Application No: AB/39/21/DOC

Site Address: 19 Maltravers Street Arundel BN18 9AP

Description of works: Approval of details reserved by condition imposed under ref AB/125/20/L relating to Condition Nos 3 - details of junction between elevation of extension & flat roof including materials, 4 - materials & finishes for brick & brick bond, 5 - details of new external door including materials, finish & method of glazing, 6 - materials & finishes for rooflight and 7 - details of internal window including proposed glazing.

Section A-A

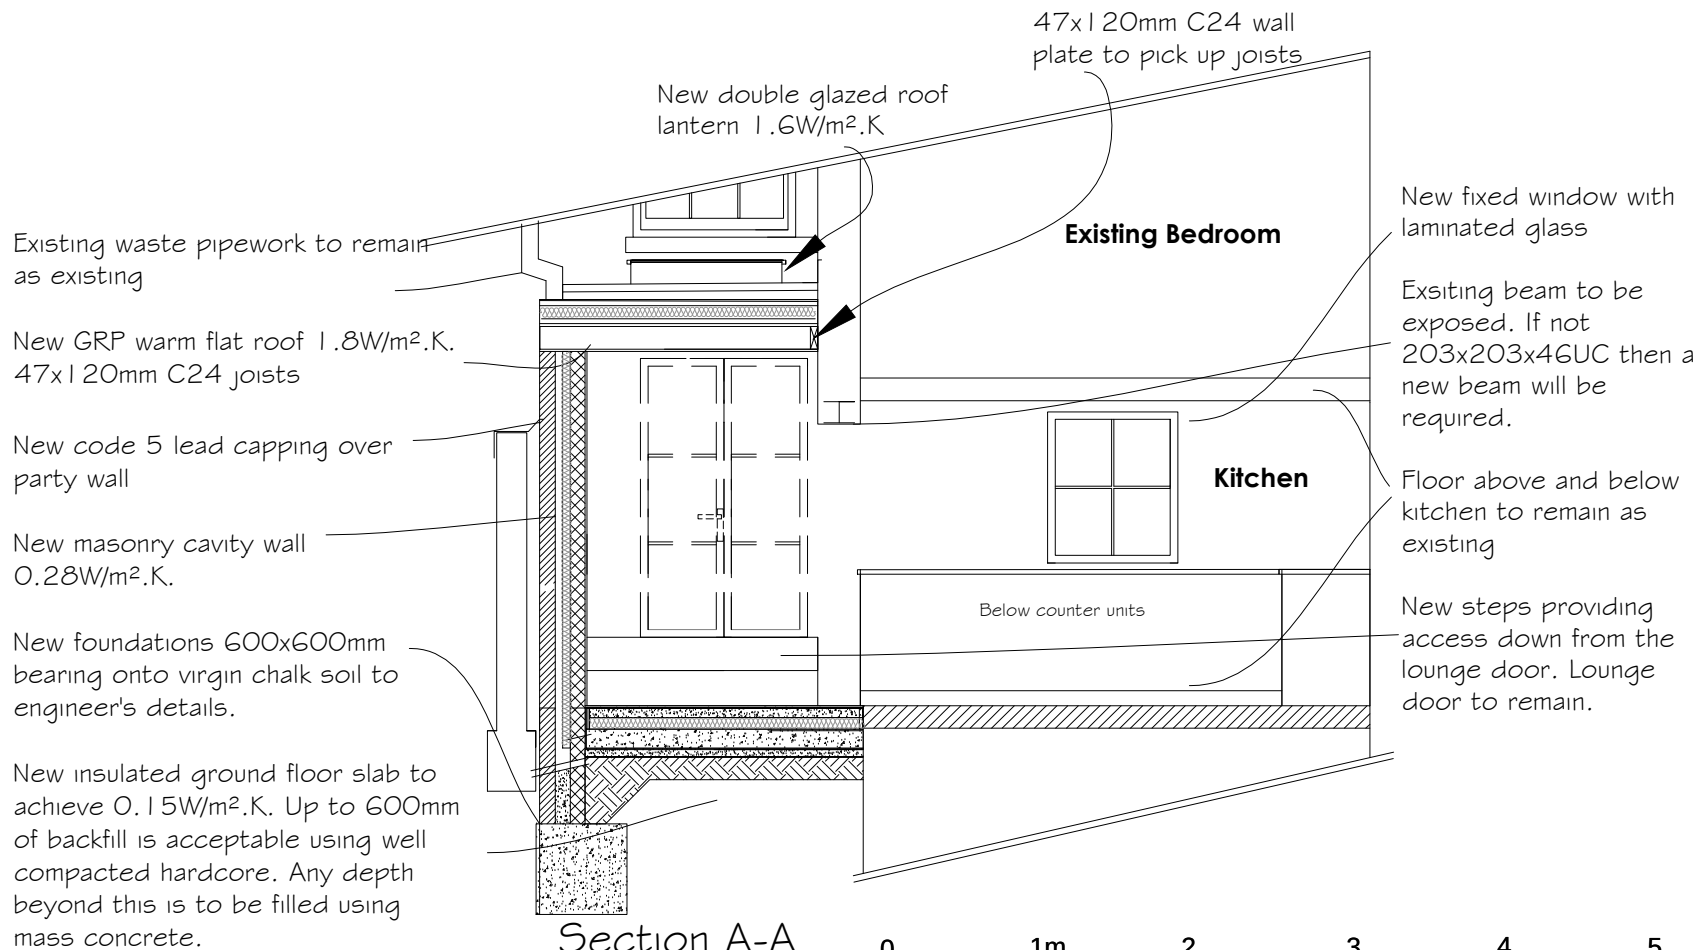
No elevational plans are provided showing the junction between the roof and the external wall of the proposed extension. It would appear from the Agent's correspondence that there will be a painted timber fascia but no details of its depth are provided. Given the age, style and heritage significance of the host building a better solution, rather than a fascia board, would be a small parapet with a stone or reconstituted stone coping. If the Council considers that a timber fascia is suitable then it should be ensured that it is not significantly deeper than the external rainwater gutter.

The use of pvcu rainwater goods as proposed in the agent's correspondence is not appropriate for a Listed Building and cast iron or, given that it will be attached to the new extension, black painted aluminium would be appropriate.

It is considered that the relevant conditions should not be discharged until more appropriate and acceptable details are submitted.
